Project Name: *Cherry Hills Unit 1*

RE: Request for Final Sign-Off for Southwest Federal Credit Union

On behalf of the applicants, we request a final DRB sign-off for the property legally described as. On June 10, 2010, the Environmental Planning Commission conditionally approved a Site Development Plan for Building Permit. This document outlines how each EPC condition has been met. Conditions are in normal text; *applicant responses are italicized.*

On June 10, 2010 the Environmental Planning Commission voted to approve Project 1008147/10EPC-40026, a Site Development Plan for Building Permit, for Tract C1A4A Cherry Hills Unit 1, based on 13 Findings and subject to the following Conditions:

SOUTHWEST FEDERAL CREDIT UNION
LANDSCAPE PLAN

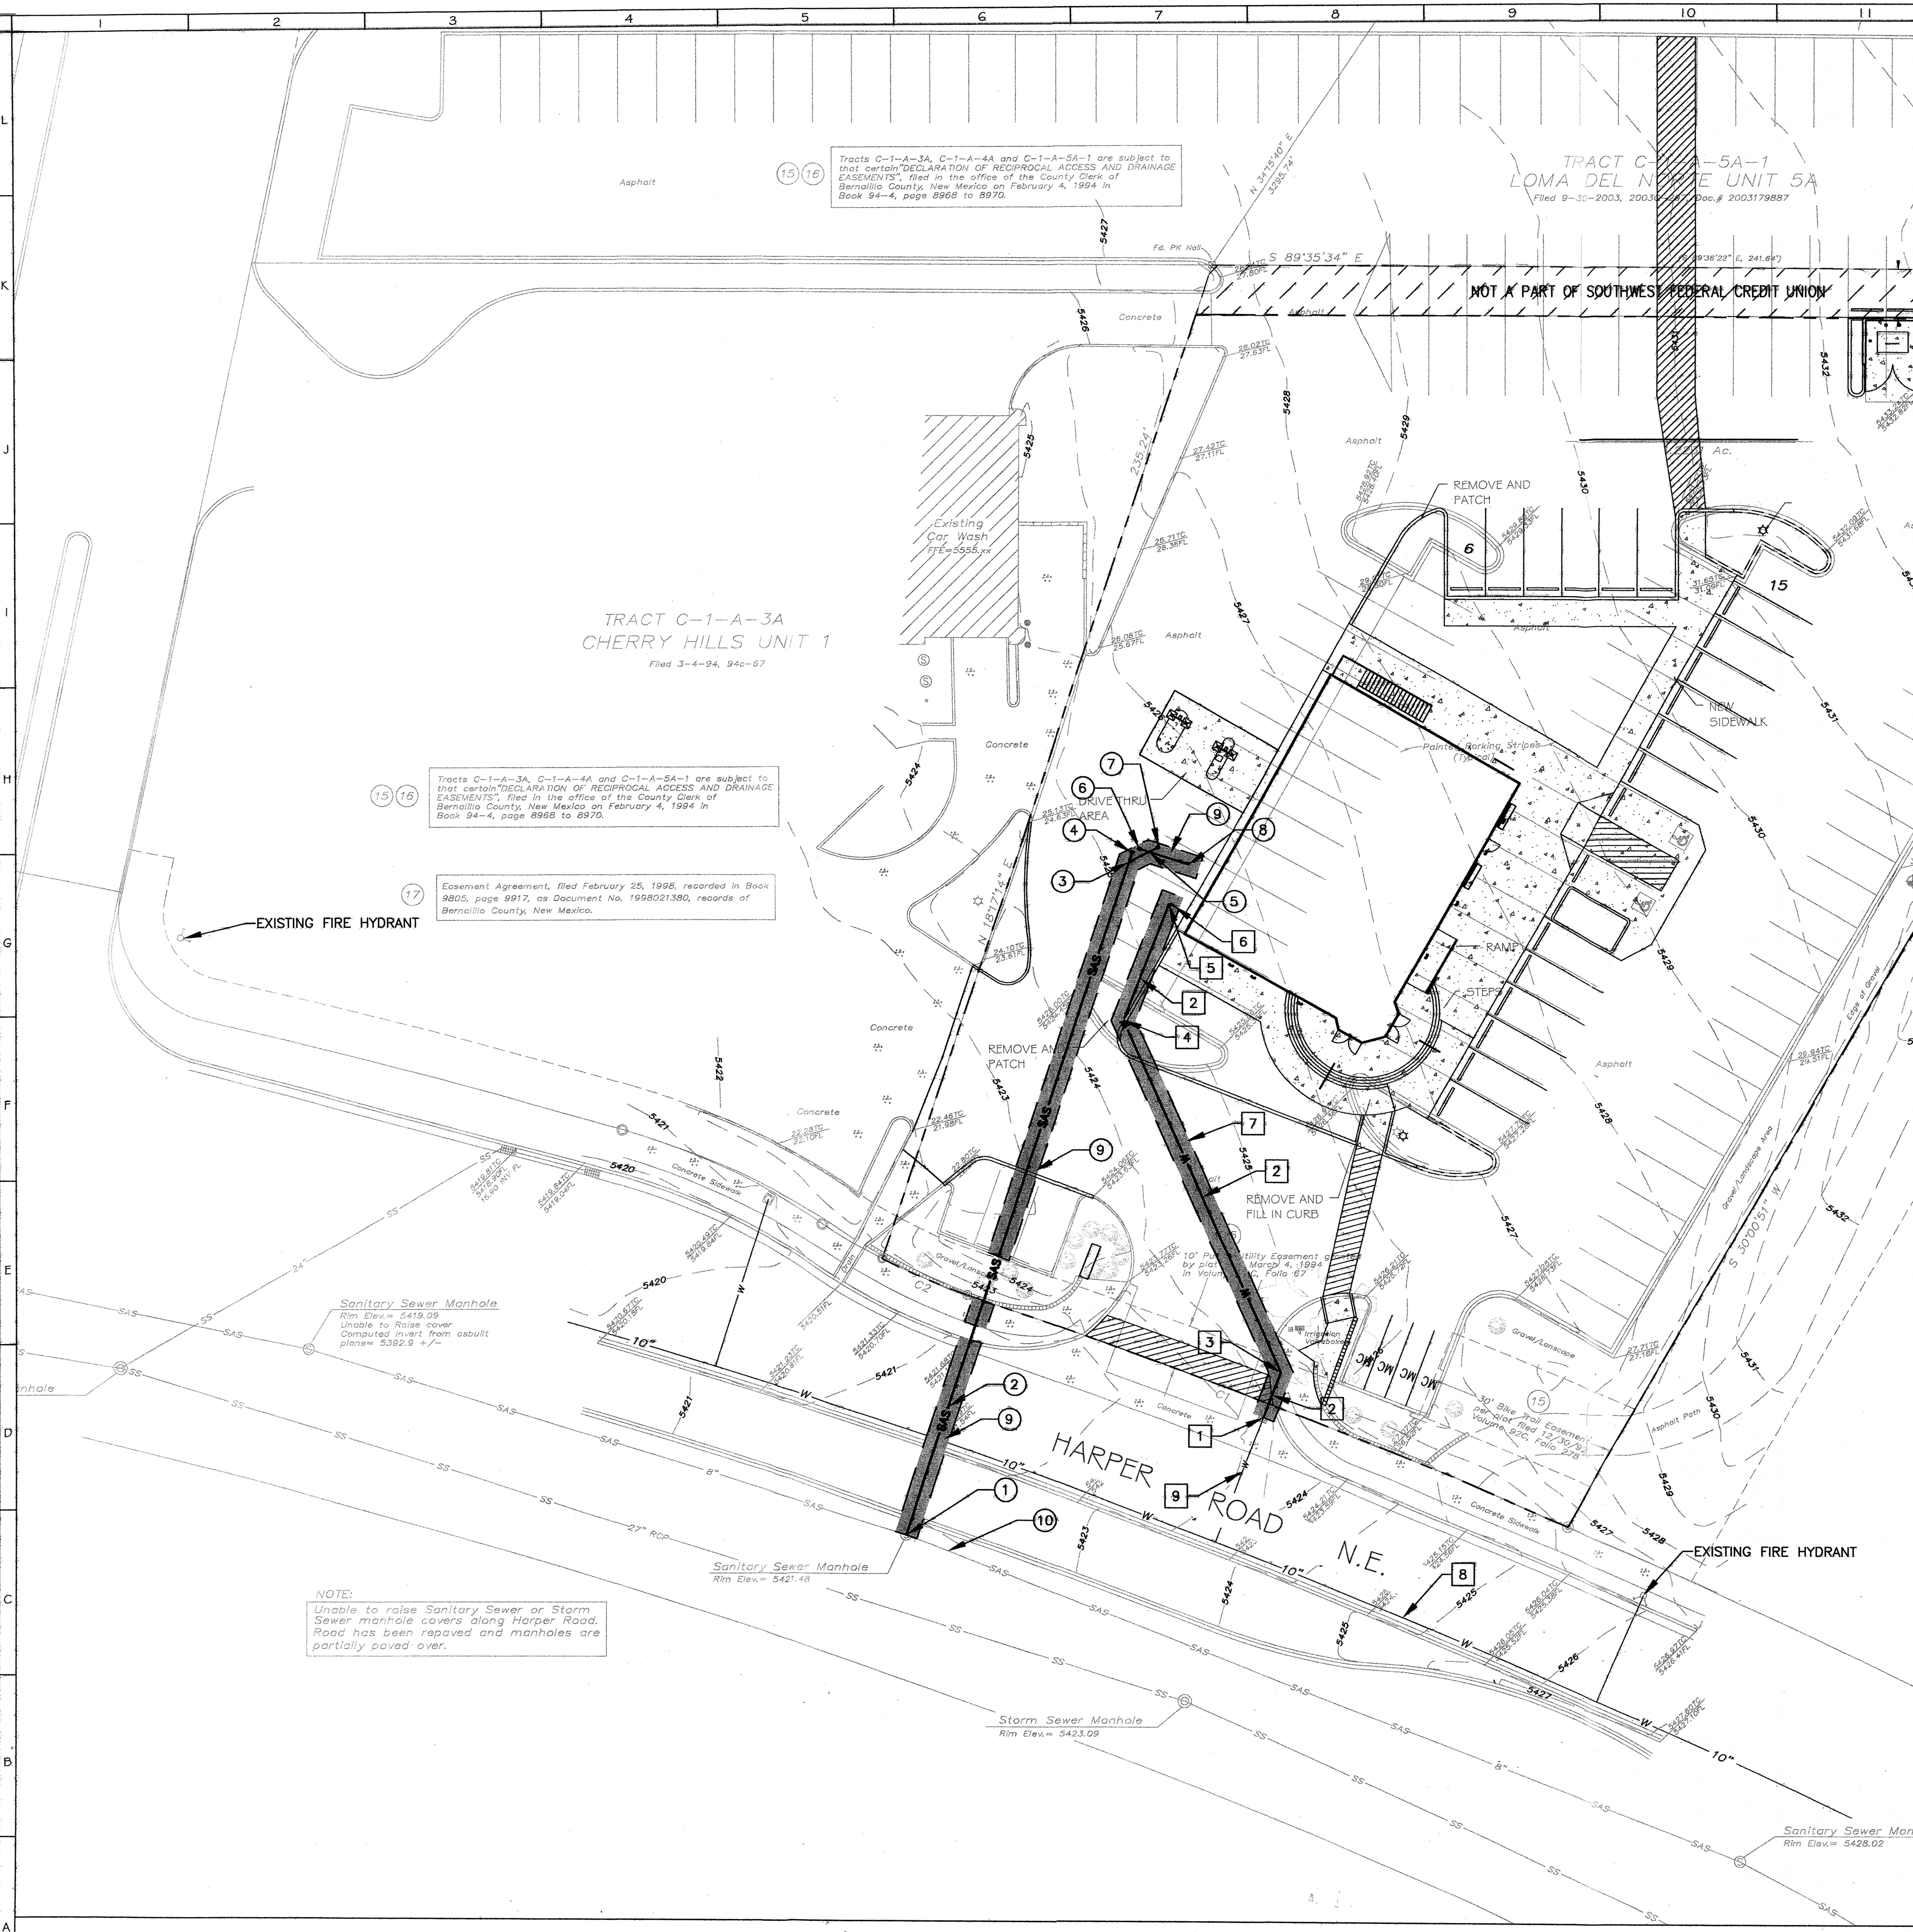
10. The Landscape buffer on Harper Road shall be widened to ensure an average of 20 feet and designed in coordination with the Traffic Engineer. Additional changes associated with the widening are:
The average landscape buffer is 30 feet 2 inches.

- c. The three car parking spaces west of the site drive shall be eliminated, which shall also be reflected in revised parking calculations.
The three parking spaces were eliminated (see condition 8.f) and the parking calculations have been revised.
- d. The three new street trees shall be placed outside the 10' PUE.
Agreed, the landscape plan has been modified to reflect this condition.

1 NORTHWEST ELEVATION
A-303 SCALE: 1/4" = 1'-0"
0' 2' 4' 8' 16'

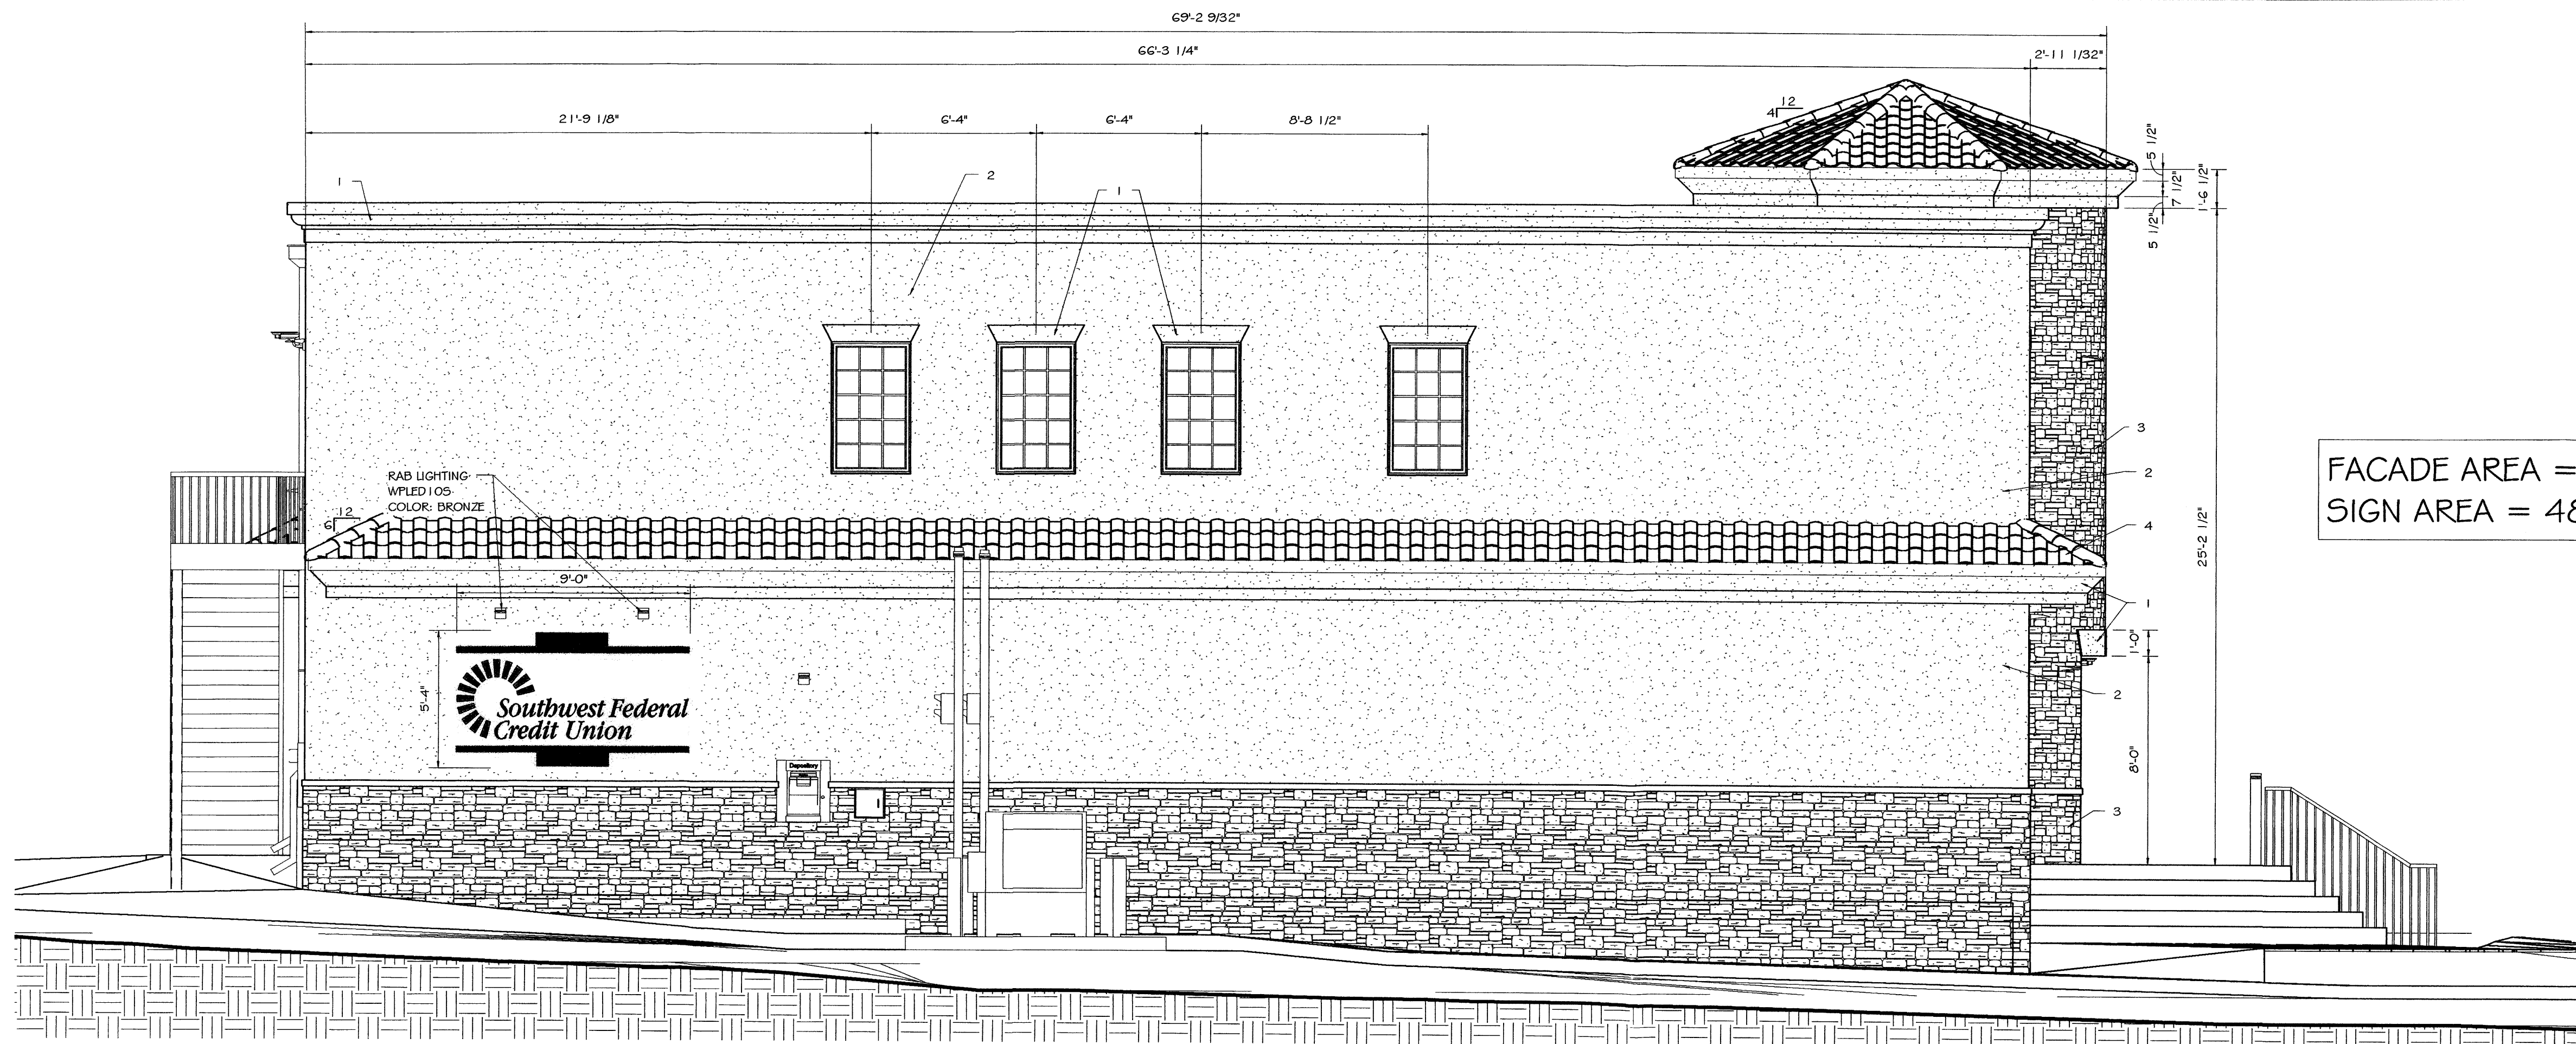
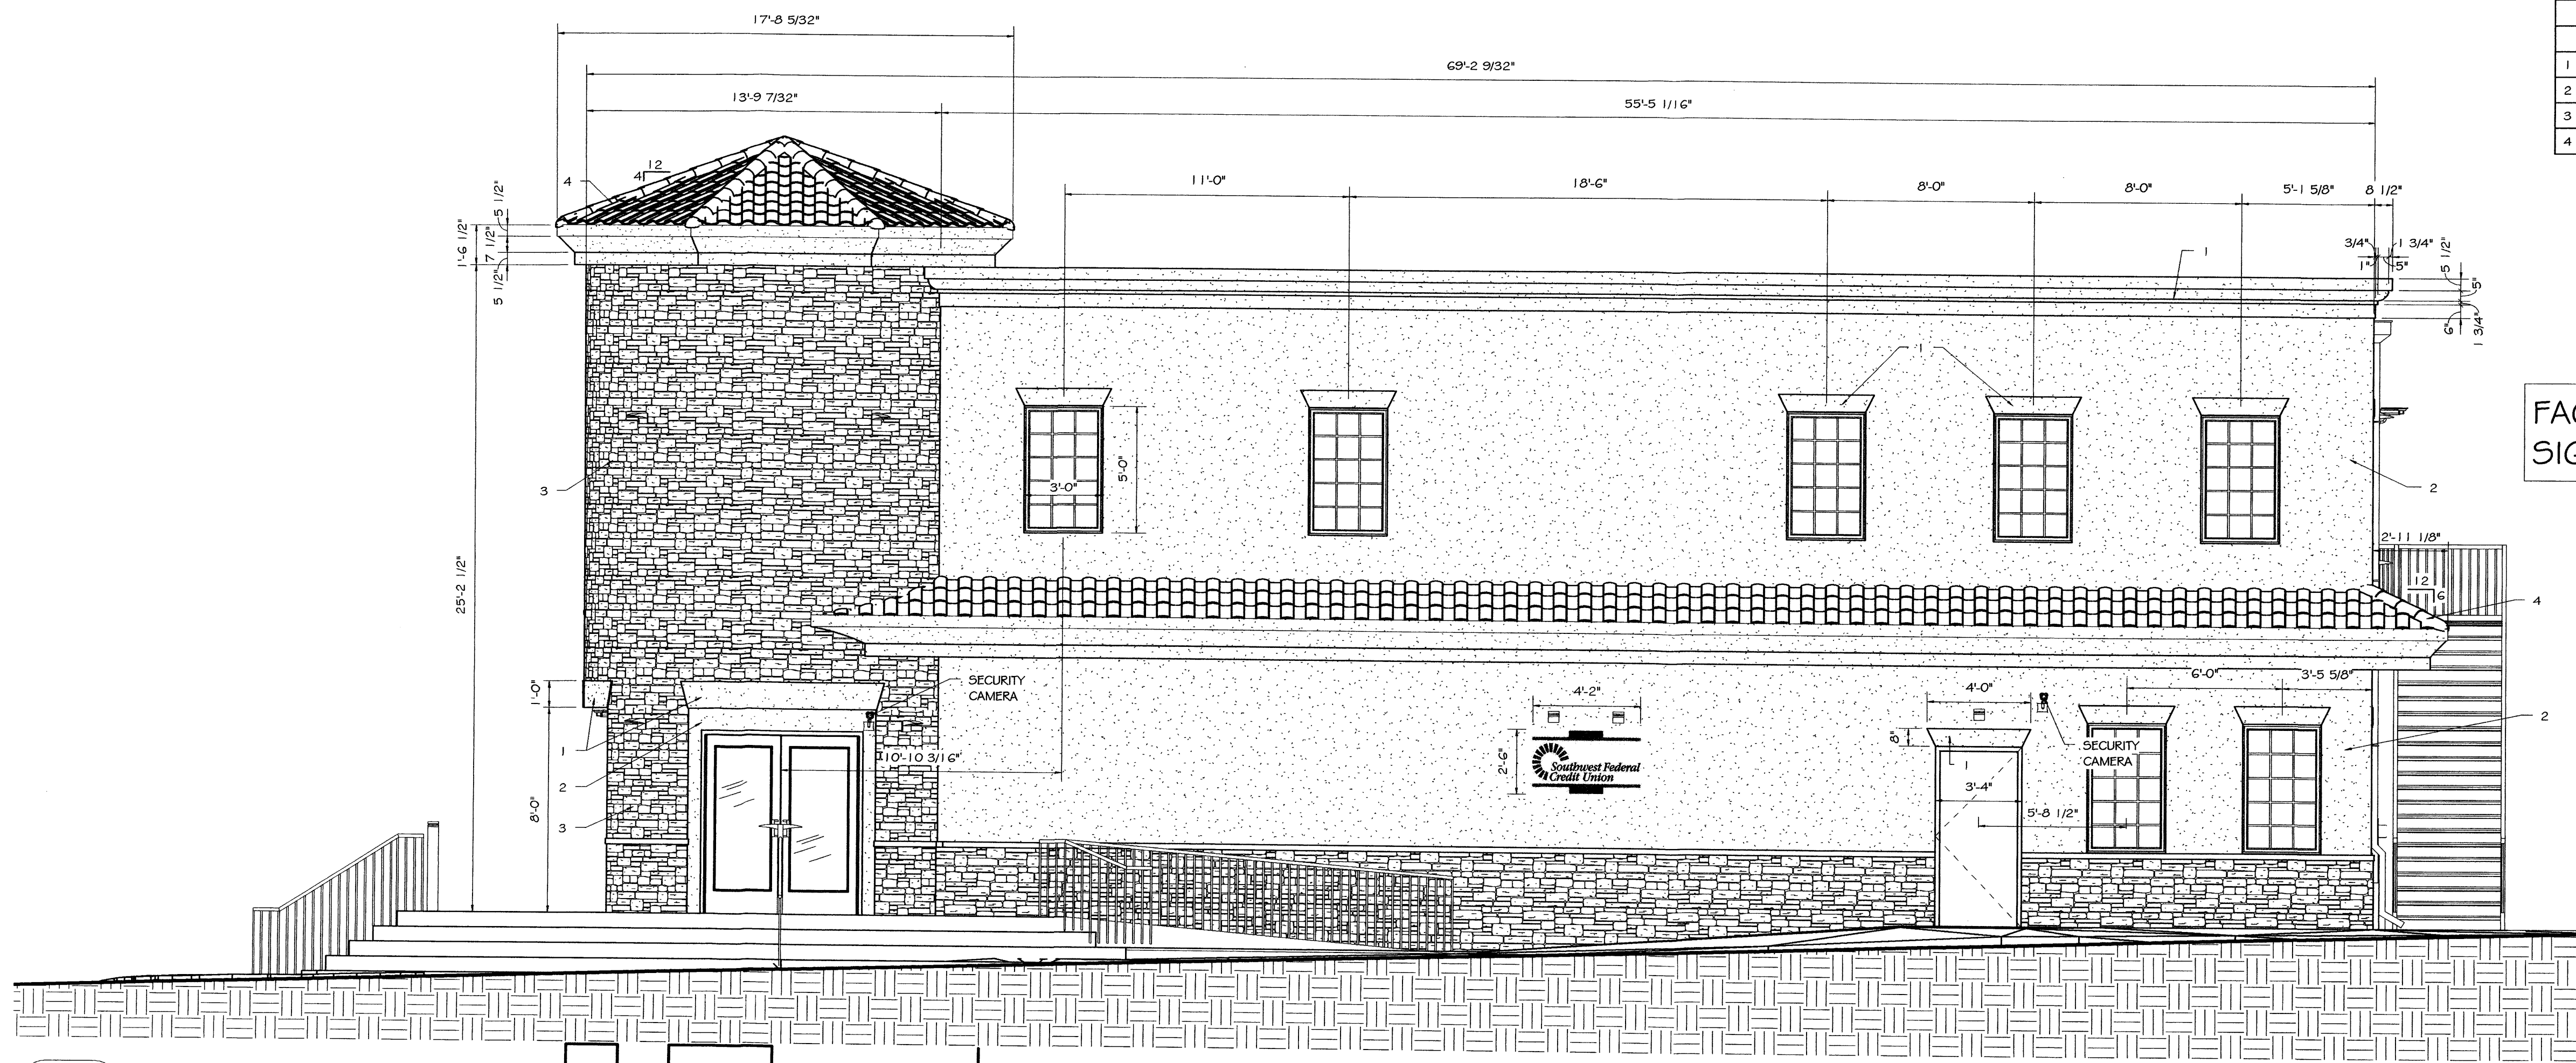
- d. Any building-mounted light fixtures at the second story level that are not illuminating signage or entryways, shall be eliminated or relocated to the first story level to illuminate walkways.
The elevations have been modified to reflect this condition.

- a. The wall signs shall be lowered to a maximum height of 16' from the average grade adjacent to each façade and shall be redesigned to consist of individual letters. Any fixtures that provide down-lighting on the signs shall comply with general area lighting and sign regulations in the Zoning Code.
The building elevations have been revised to reflect the lower sign locations to comply with this condition.
- b. Provide calculations to demonstrate that the sign area face of wall signs complies with the 6% limit of related façade area, per a General Note on the site development plan (Sheet 1).
The sign and façade area calculations are provided on the elevation sheets. The large signs are less than 3.5% of the façade area and the small signs are less than 1%.
